From: Katherine Lafferty <KLafferty@cityofparramatta.nsw.gov.au>
Sent: Friday, 1 February 2019 10:43 AM
To: Patrick Copas
Cc: Myfanwy McNally; Ferdinando Macri
Subject: Council Submission - Viva Energy (formerly Shell) Clyde Terminal (SSD 5147 MOD 1)

COUNCIL SUBMISSION

Viva Energy (formerly Shell) Clyde Terminal (SSD 5147 MOD 1)

Figure 5 | View of the State Office Building and associated landscaping (proposed to be demolished)

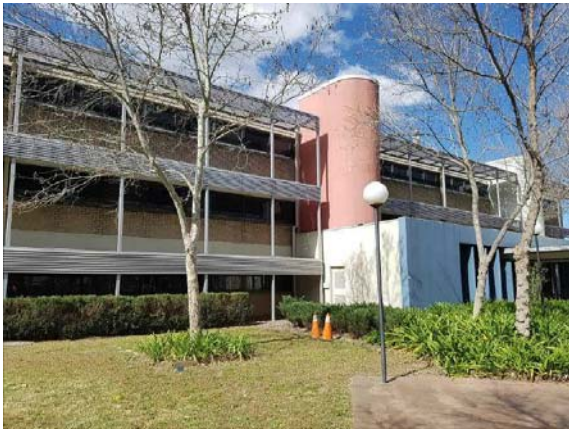
The modification states that there is a need for tree removal, however there are no details provided on the extent of tree removal or nature of the trees to be removed. Approval should not be granted without details of the tree removal as a proper assessment of their removal cannot be appropriately undertaken.

In this regard, an Arboricultural Impact Assessment (AIA) and Tree Protection Plan (TPP) prepared by an AQF Level 5 arborist must be provided for assessment. The AIA shall identify all trees equal to or greater than five (5) metres in height located within the subject site and adjoining properties where located within three (3) metres of the common property boundary or where a tree protection area extends into the development site. The report must identify all trees proposed to be retained or removed as a result of the proposed works and quantify any potential impacts incurred.
